From: Michael Pickup [REDACTED]
Sent: 04 July 2012 10:07
To: Susan Leeson
Subject: RE: Planning application no. EG/35/12 - FAO Mrs S Leeson
Attachments: TCPS 479A Amended Site Location Plan Drawing 04.07.12.pdf

"Retention of horsebox hire business, mobile home, office/staff room, workshop/storage building and an area of hardstanding".

Drawing No. TCPS 479A/1

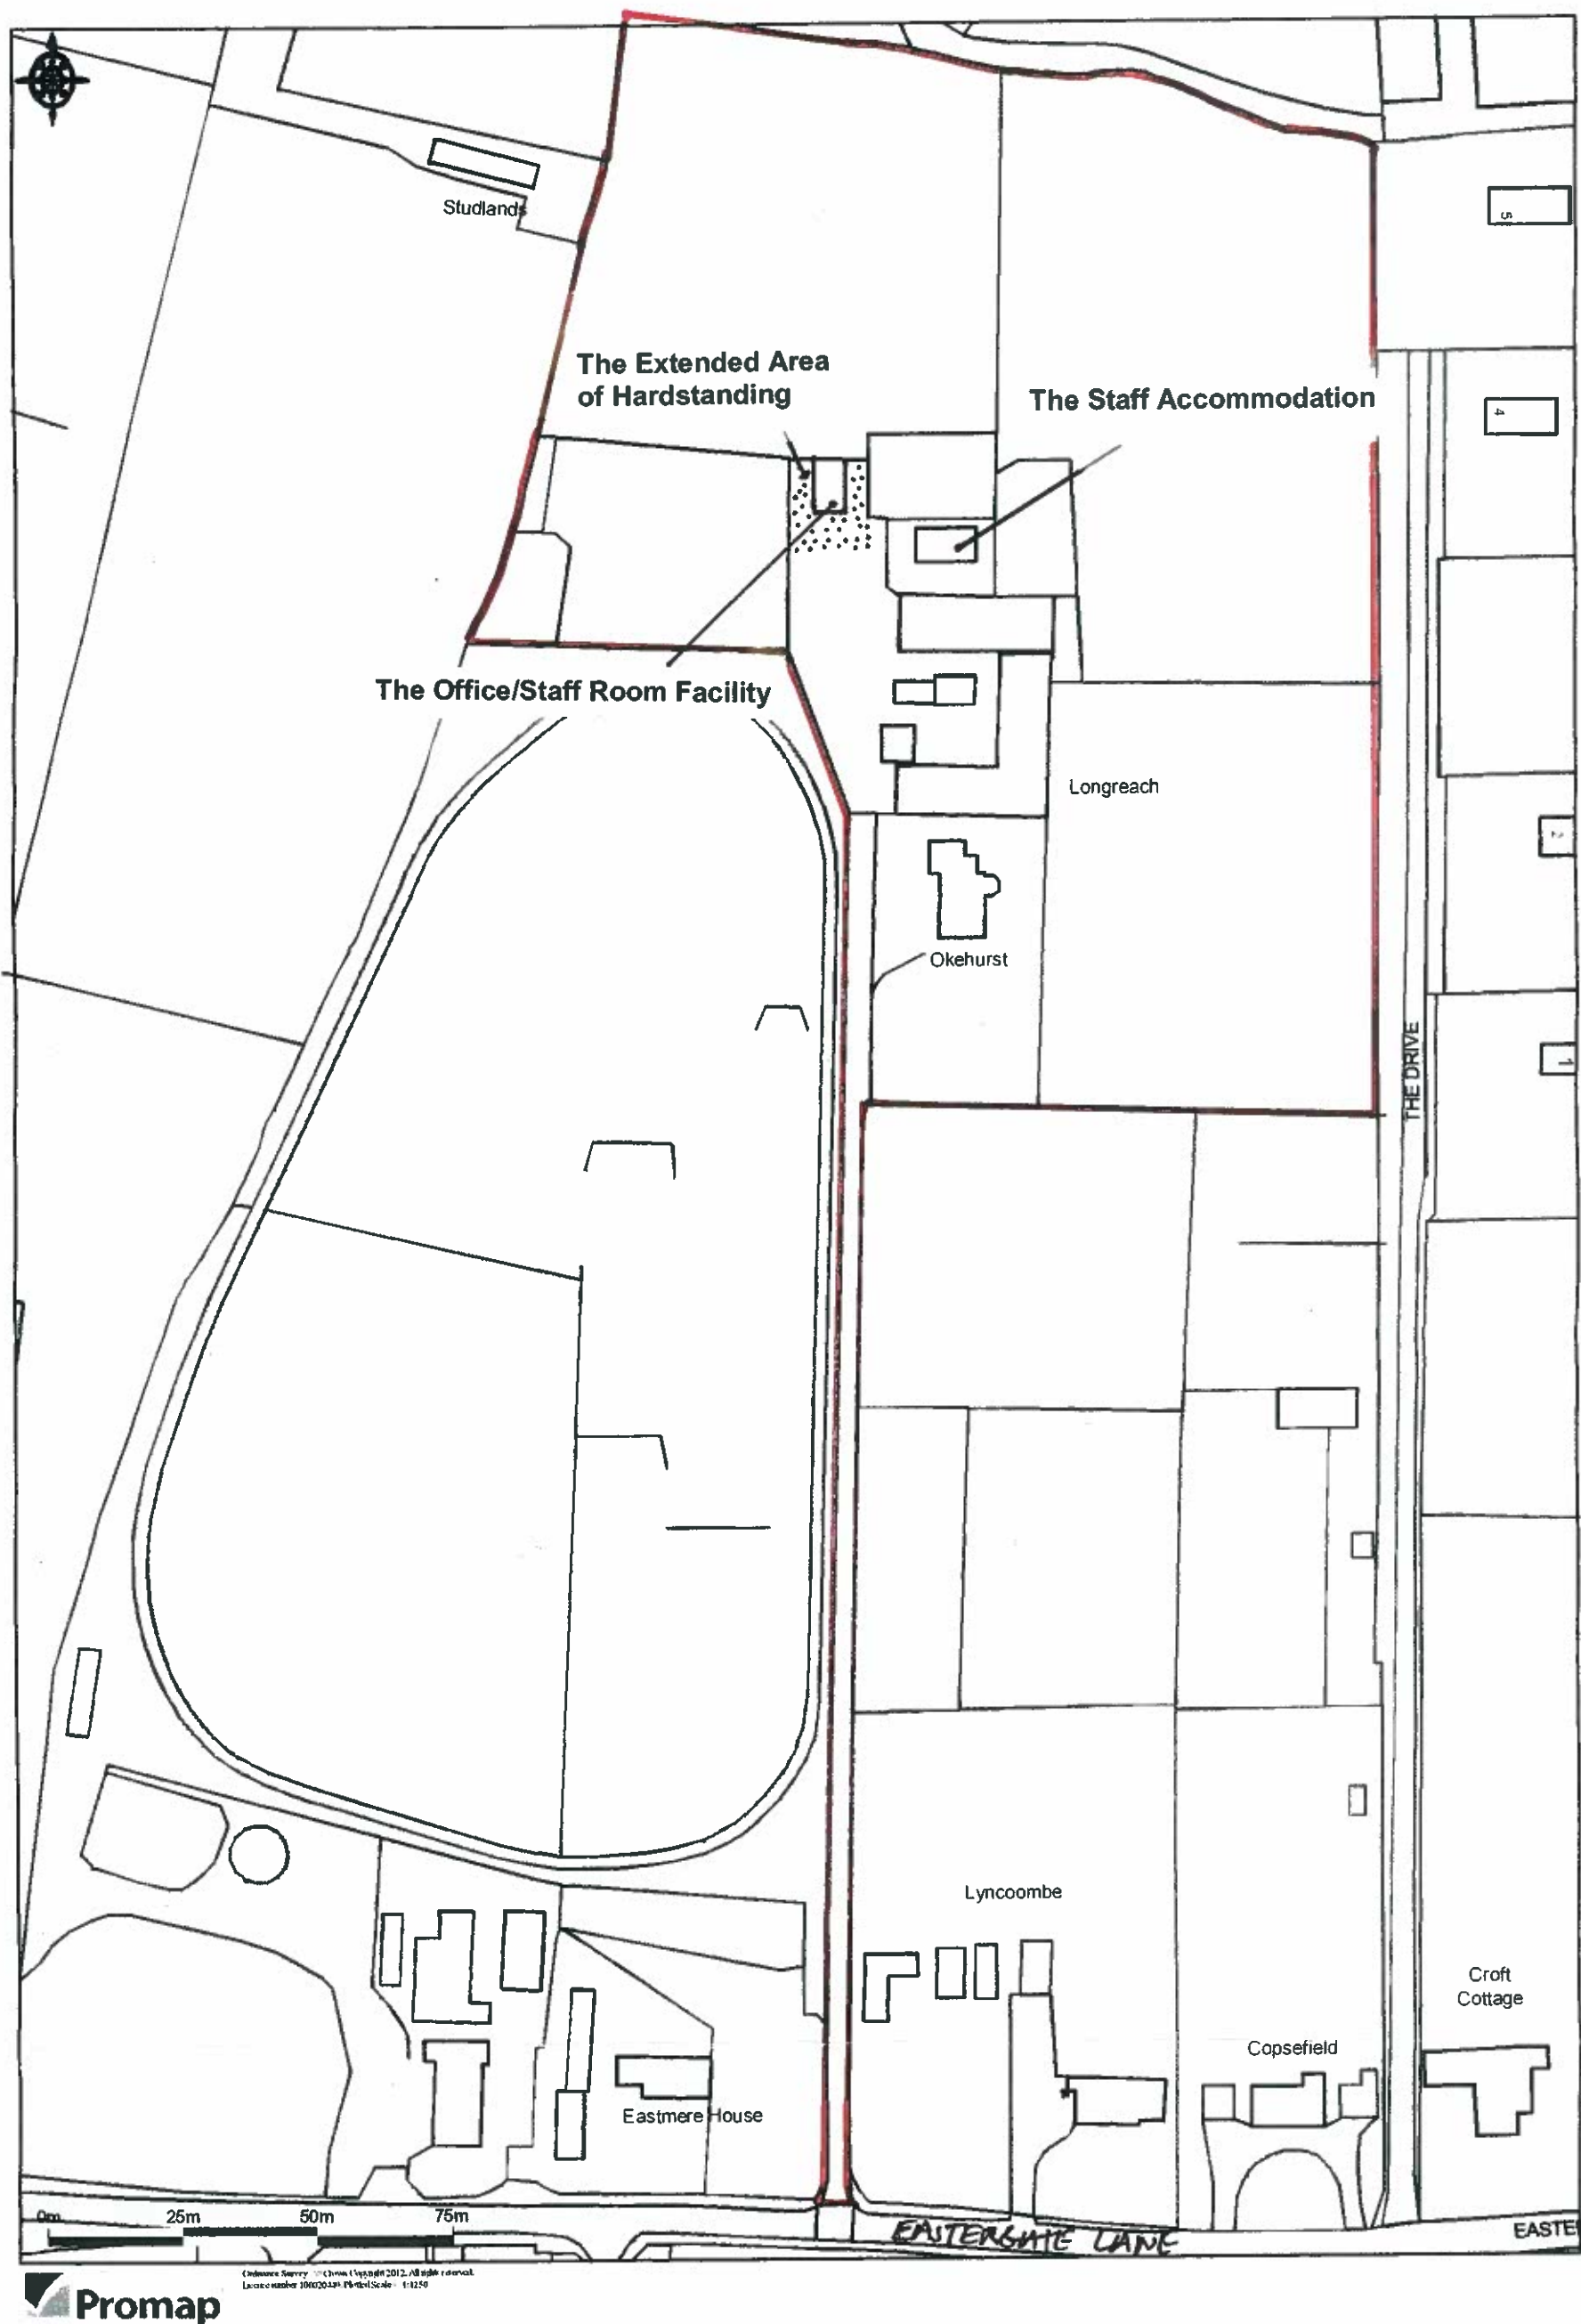
Thank you, please can you also send a revised site, block plan to include the barn.

The amended drawing (no. TCPS 479A/1 Rev B) is attached. I have also deleted two buildings in the central courtyard area as these no longer exist.
